6 June 2016

Mr Brendon Roberts  
A/ Team Leader – Key Sites Assessment  
NSW Planning and Environment  
GPO Box 39  
SYDNEY NSW 2001

## **RESPONSE TO NOTICE OF EXHIBITION – SSD 7445 Site 9 SYDNEY OLYMPIC PARK**

Drawing no. **DA02.001** Revision **A**

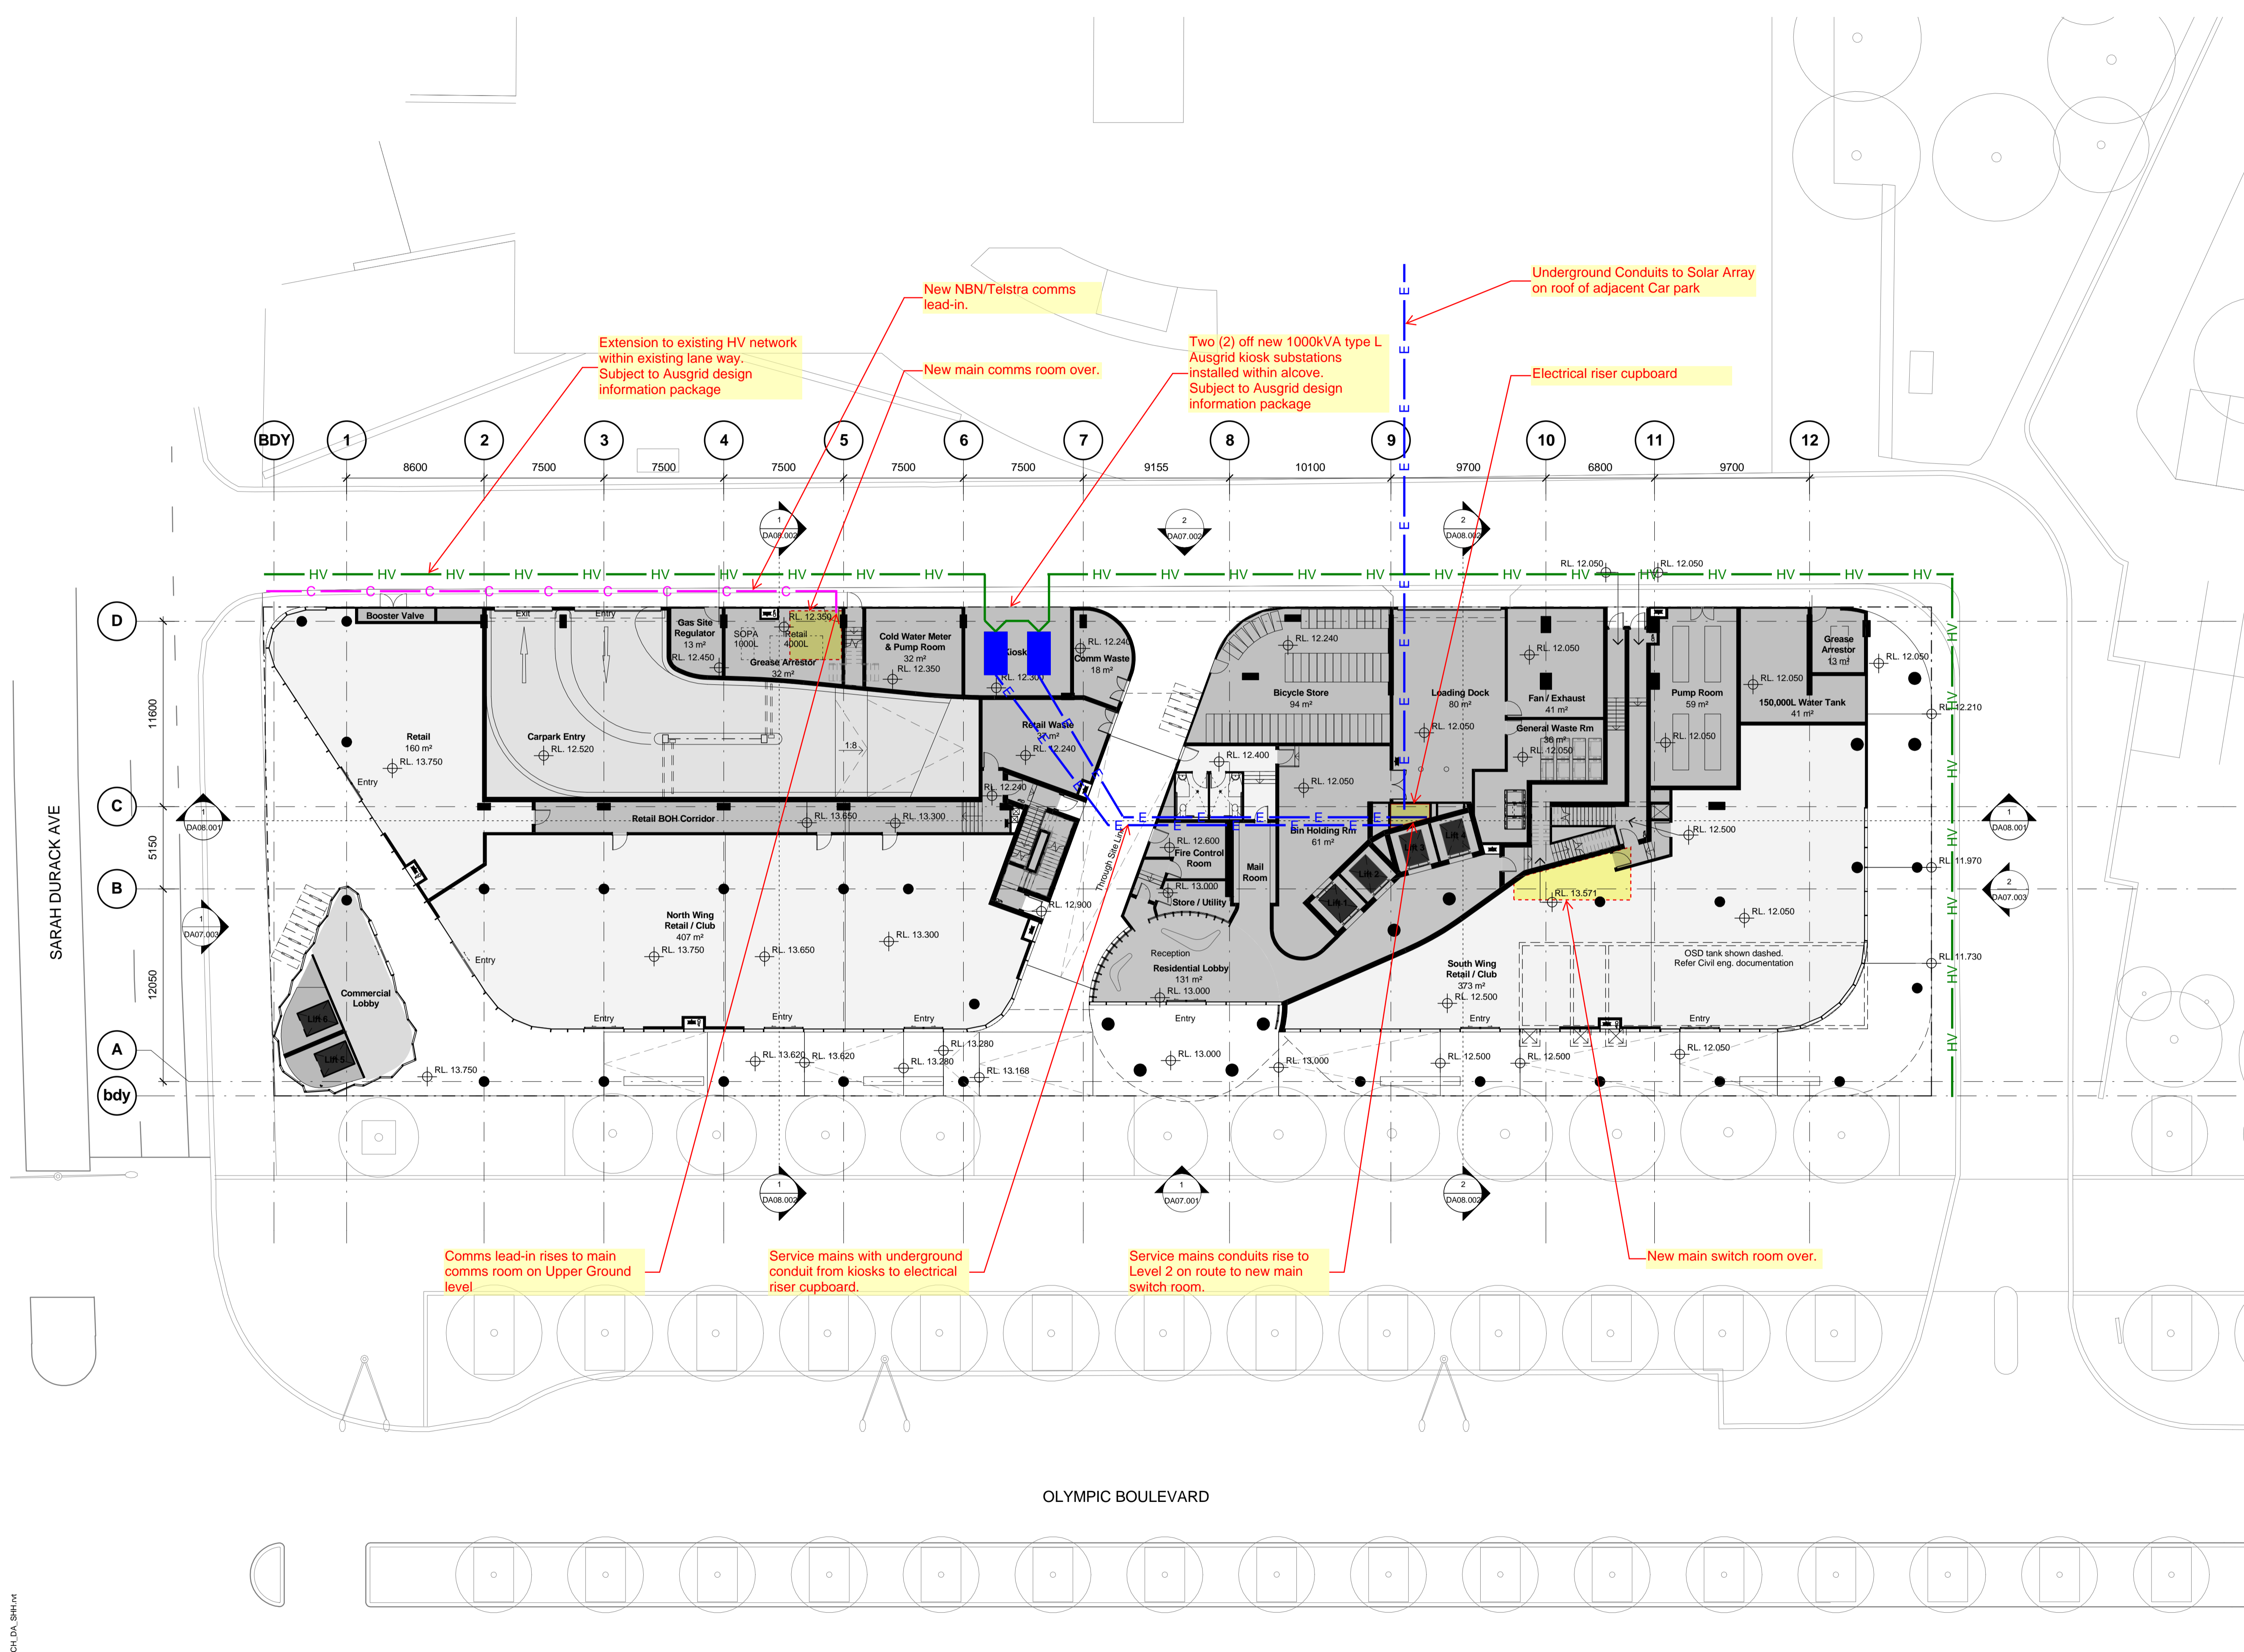
The ground level of the building is heavily encumbered with plant and services which occupy more than 50% of the ground level frontages. These impact on the size of ground level retail tenancies and the residential lobby and create long stretches of bland and inactive frontages in areas where high pedestrian use is expected.

- 1. Consider increase activation of ground level floor space, particularly along the through site link.*

Drawing no. **DA02.007** Revision **A**

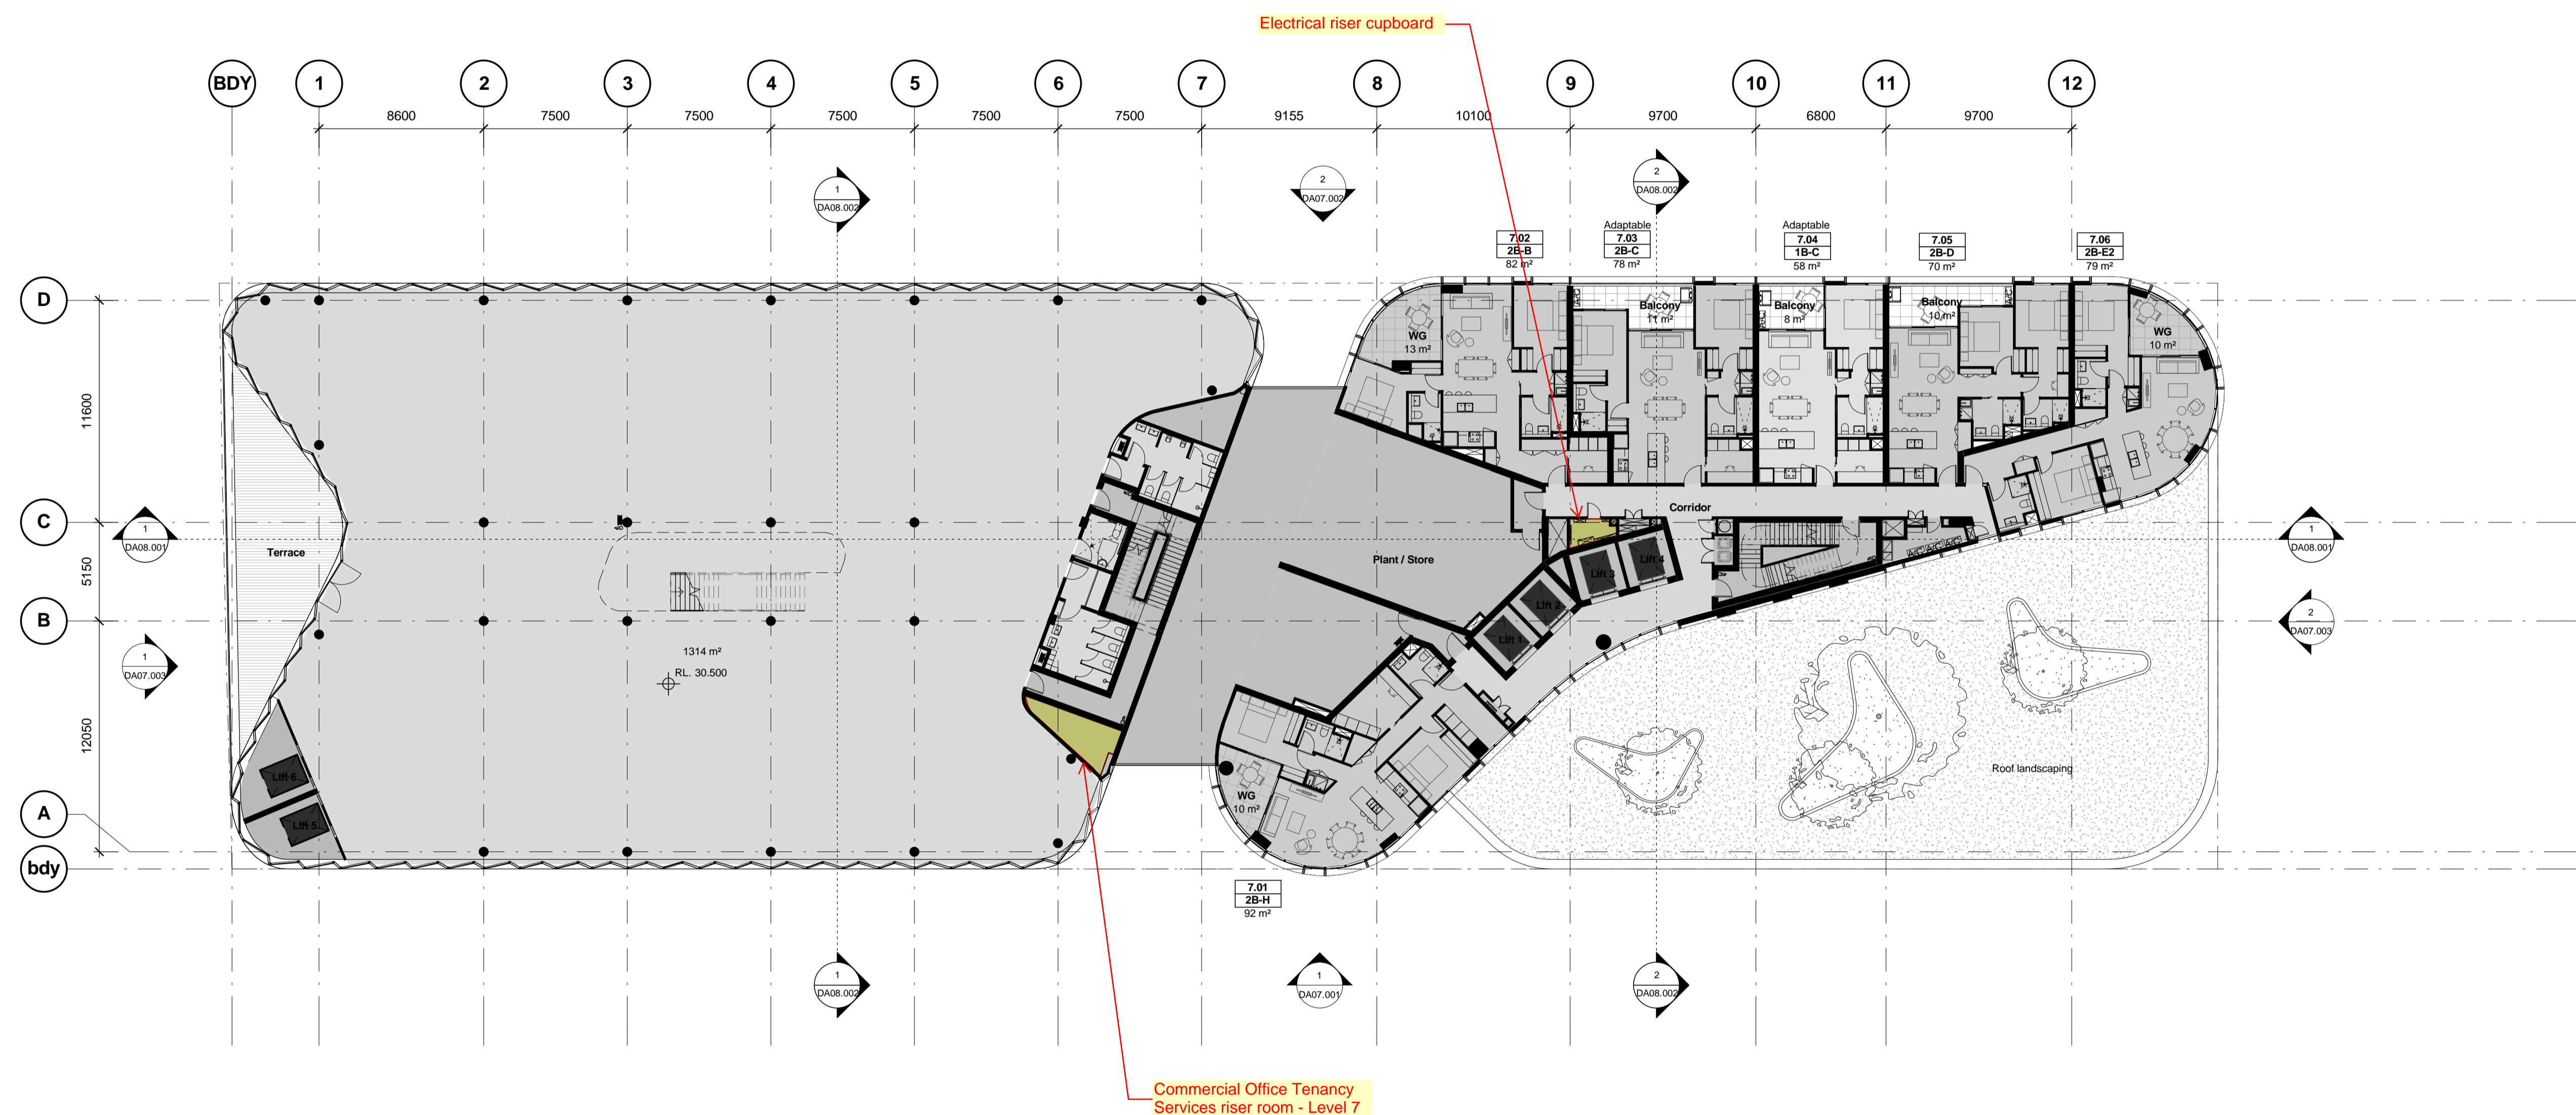
As currently planned, The Level 7 South Podium roof space cannot be accessed. Whilst it is understood that the space is likely to be subject to downdrafts and wind turbulence, this area is a significant exterior asset to the building and has potential to be better utilised.

1. Part of the level 7 roof space could be utilised as external private space for each of the two dwellings facing onto the space to create garden apartments.
2. Provide a connection from the lobby so that the remainder of the space is accessible to residents as an alternative green landscaped passive communal recreation area, when weather conditions permit.
